EPC STORMWATER REVIEW COMMENTS
IN ORANGE BOXES WITH BLACK TEXT

BRADLEY POINT FILING NO. 1-DRY SUBDIVISION SITE DEVELOPMENT PLAN

BRADLEY POINT FILING NO. 1
SITE DEVELOPMENT PLAN
JOB NO. 70-077
DATE PREPARED: 01/24/24
DATE REVISED:

VICINITY MAP
N.T.S.

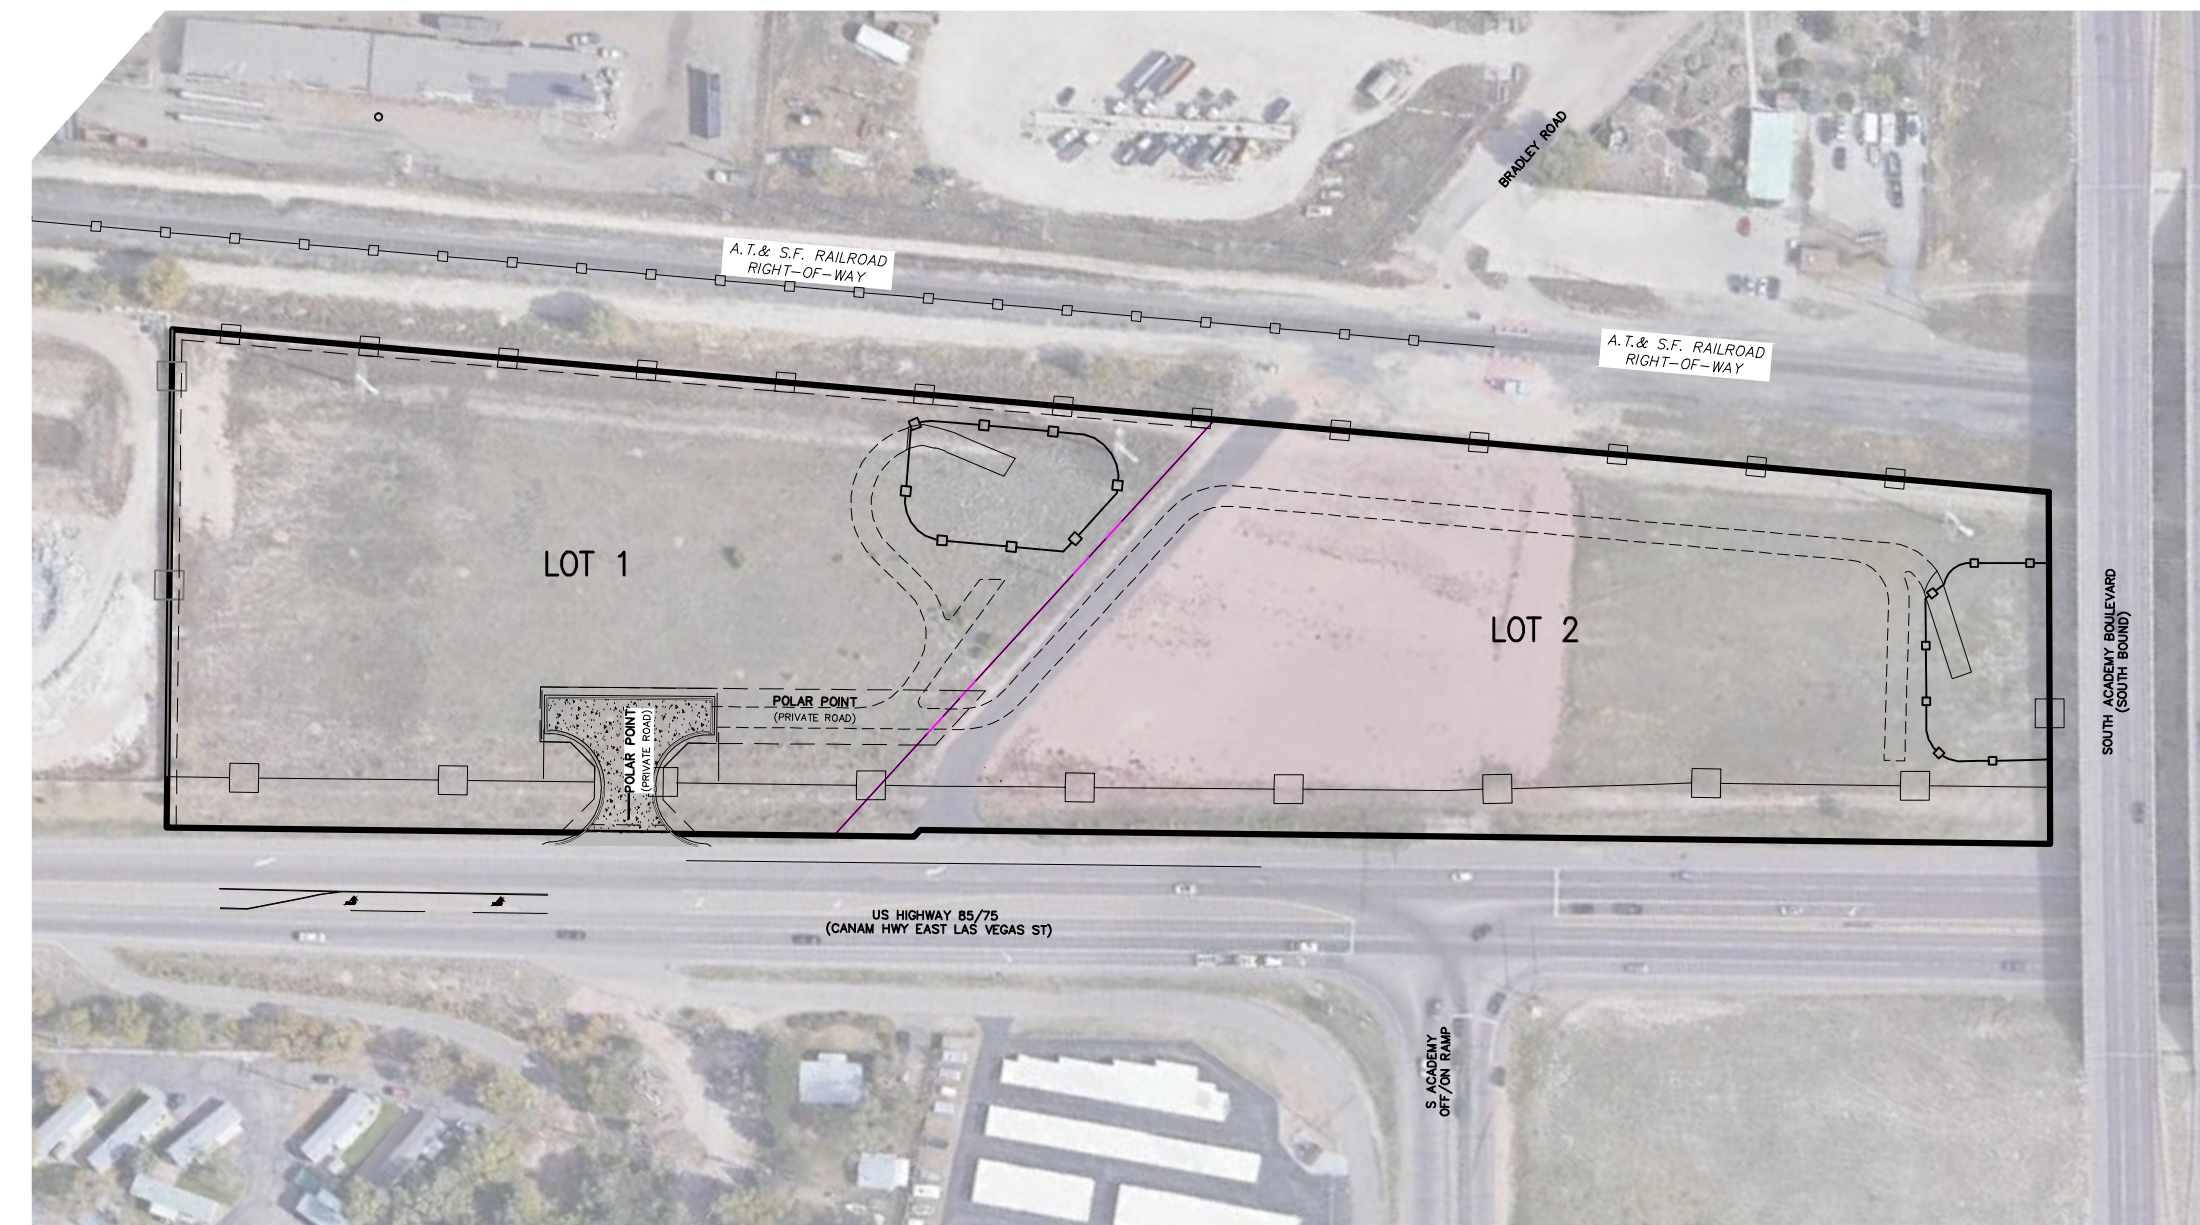
Include the quarter-section

BRADLEY POINT FILING NO. 1-DRY SUBDIVISION SITE DEVELOPMENT PLAN

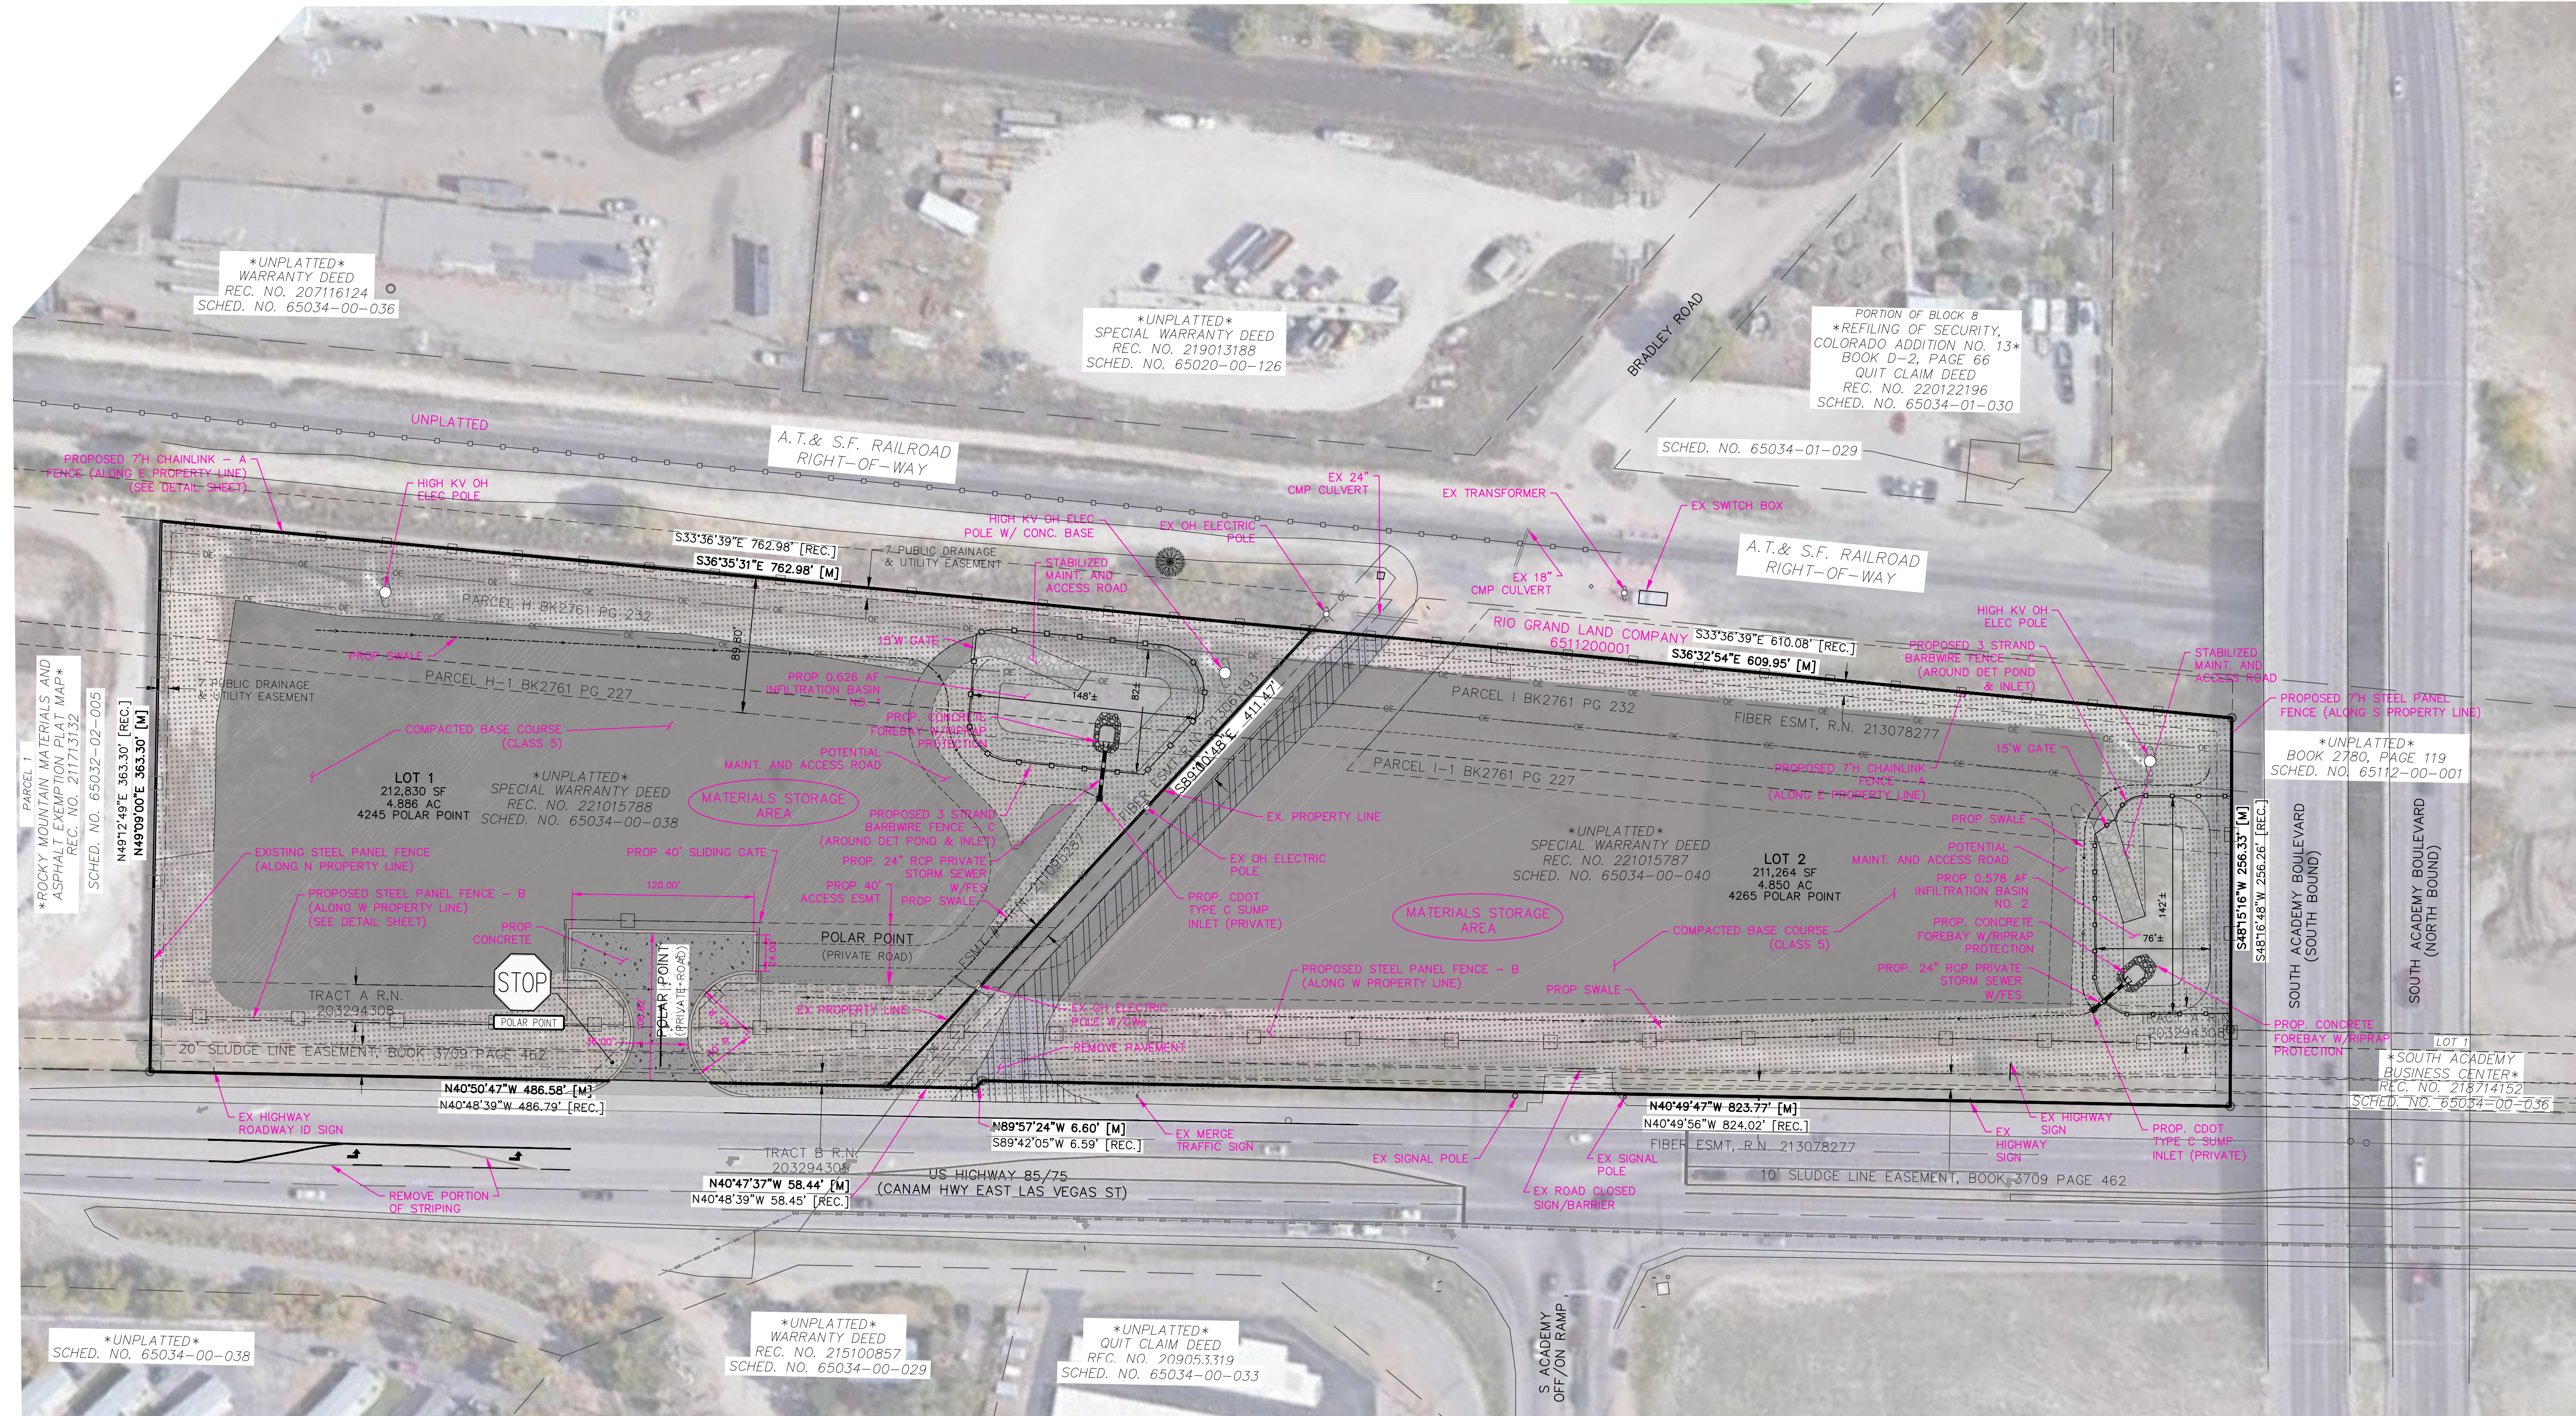
The site plan shows the access point labeled as "Bradley Point" please revise map for consistency.

Label all easements on the site plan (drainage, utility, access, etc)

Include Open space, landscaping, and impermeable surface percentages

Per LDC Sec. 6.2.5.D.1.a.vi, alternative parking ratio will need to be determined for a use not listed in the parking table. Please review that section of LDC and provide an alternative parking request in the LOI. Please also depict all proposed parking spaces.

All stored material must adhere to 15 ft setbacks on the front and rear and cannot exceed the height of the fence. Any storage exceeding the height of the fence shall be stored in the rear 1/3 of the property.
